Location of Construction: 320 Fore St		Owner: Estate of S Klaman		Phone:	
Owner Address: 320 Fore St Apt 811 ME		Lease/Buyer's Name: I Love Flowers, Inc		Phone: 774-5882	
Contractor Name: Street 04101		Address:		Phone:	
Past Use:		Proposed Use: retail w sign		COST OF WORK: \$	
				PERMIT FEE: \$ 28.20	
				FIRE DEPT. <input type="checkbox"/> Approved <input type="checkbox"/> Denied	
				INSPECTION: Use Group: Type:	
Proposed Project Description: erect sign 4'x4'		Signature:		Signature: <i>[Signature]</i>	
		PEDESTRIAN ACTIVITIES DISTRICT (P.U.B.)		Zoning Approval:	
		Action: <input type="checkbox"/> Approved <input checked="" type="checkbox"/> Approved with Conditions <input type="checkbox"/> Denied		Special Zone or Reviews: <input type="checkbox"/> Shoreland <input type="checkbox"/> Wetland <input type="checkbox"/> Flood Zone <input type="checkbox"/> Subdivision <input type="checkbox"/> Site Plan maj <input type="checkbox"/> minor <input type="checkbox"/> mm <input type="checkbox"/>

November 21, 1996

RE :320 Fore St.

Your application erect a sign has been reviewed and a permit is herewith issued subject to the following requirements: This permit does not excuse the applicant fr

Drawing file: 1. Original Plans / Sketch Plan.pdf

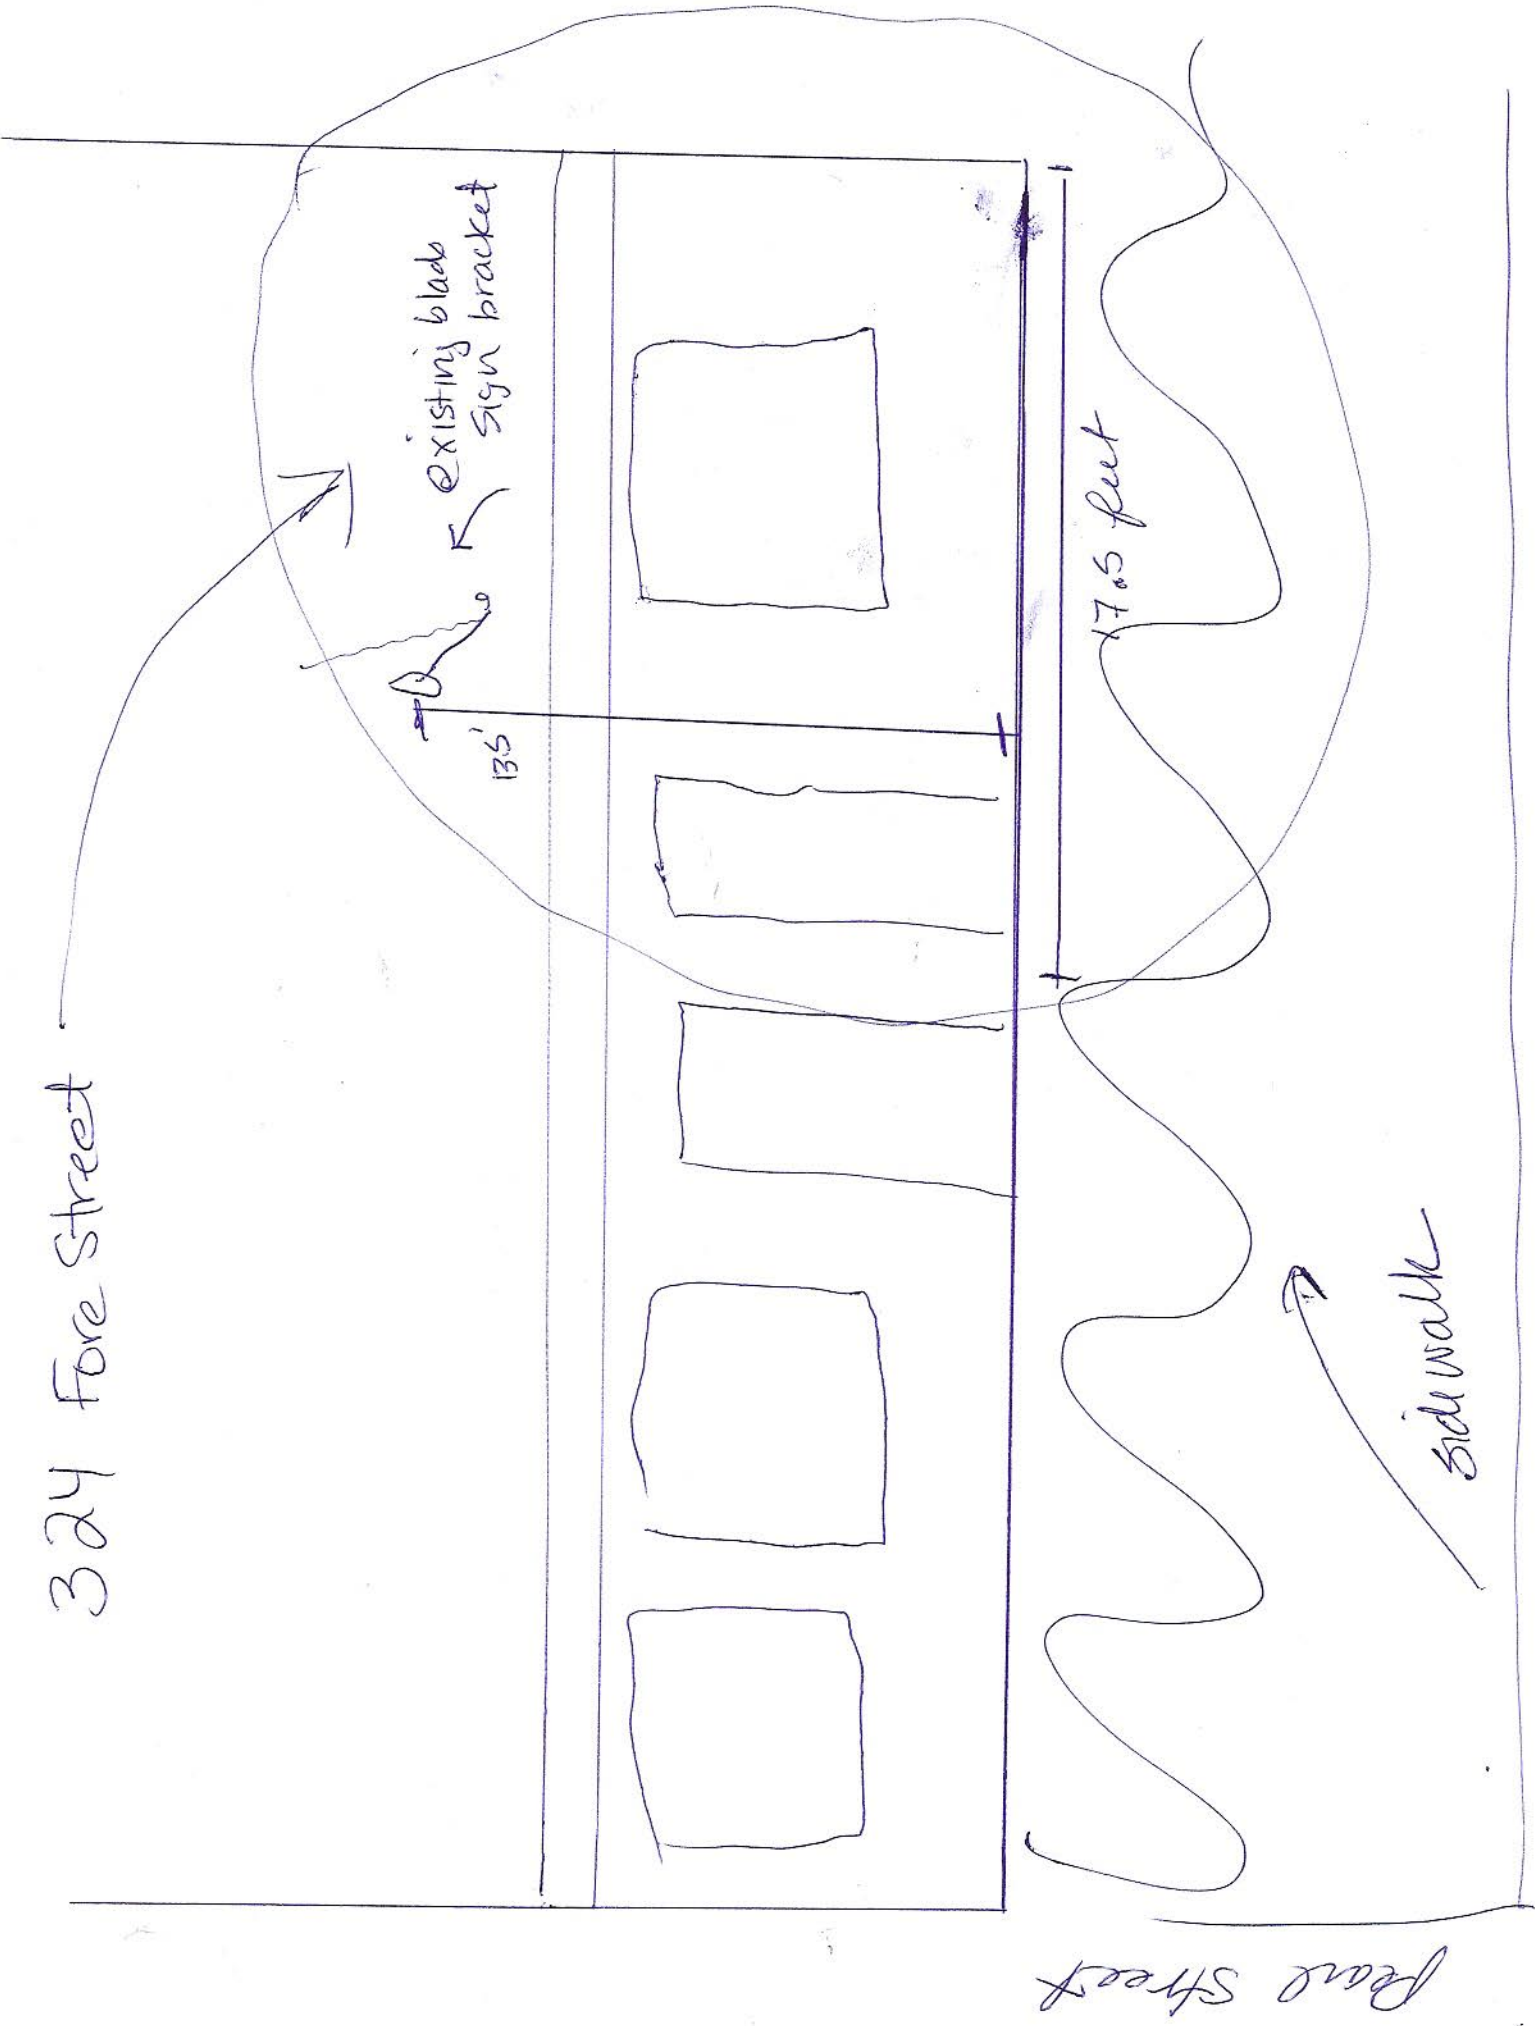
1. This permit is being issued with the condition that the banner is to be removed after the installation of the permanent sign is installed.
2. A plan must be submitted to this office showing how this proposed sign is to be attached to the building.
